RIBCHESTER PARISH COUNCIL

RE: Planning Application 3/2020/0791 – Land to the NW of The Old Police House, Preston Road, Ribchester, PR3 3XL

Ground floor

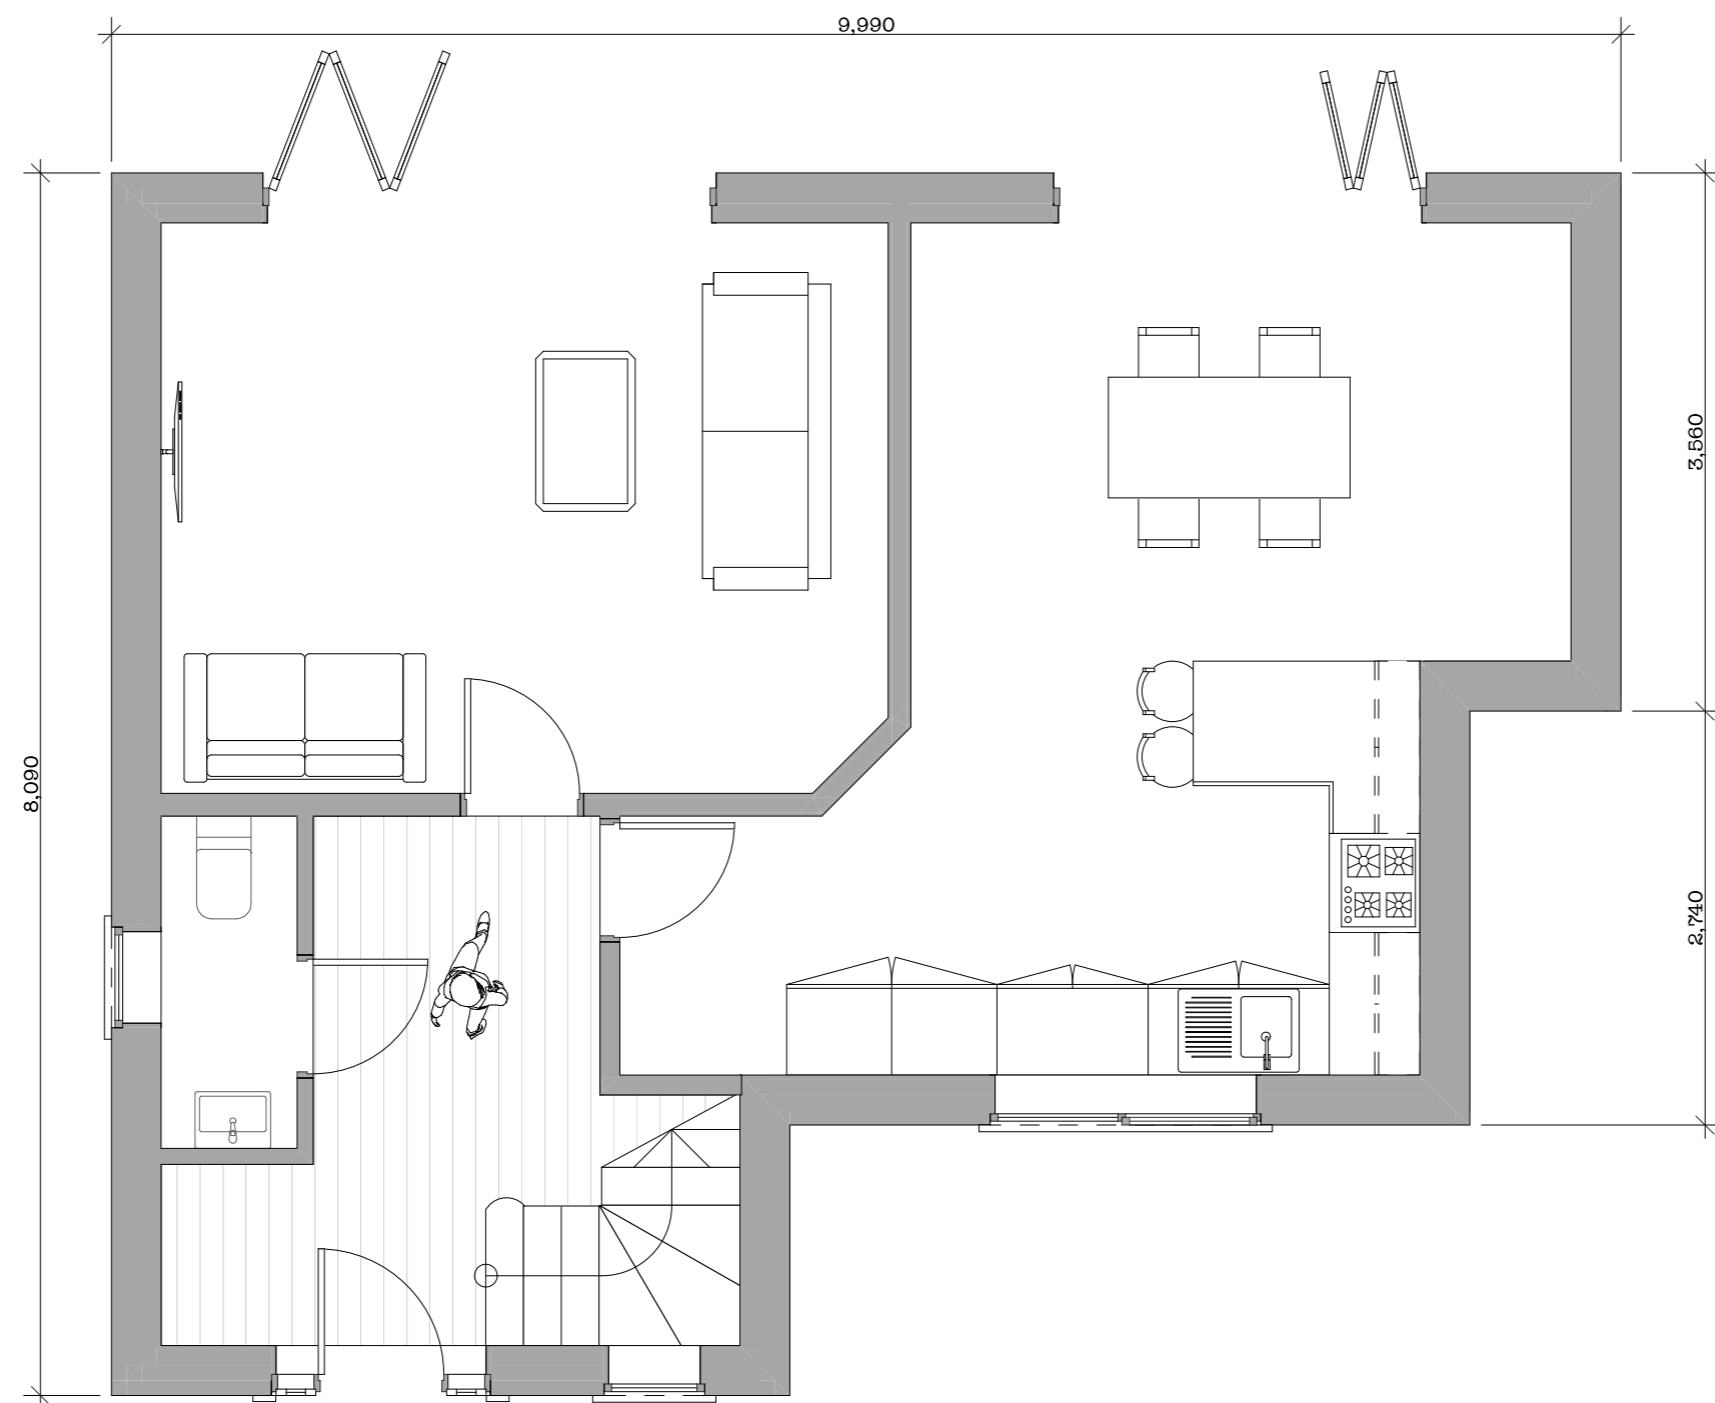
exceeded. The plan outlines that a driveway would emerge from the proposed property onto an already busy road. Residents on local roads and with house exits onto Preston Road are already experiencing difficulties in accessing Preston Road at peak times of the day. Emerging traffic from this proposed site may have to drive into an unsafe position on this busy highway in order to get a clear sight of on-coming traffic (moving at speed).
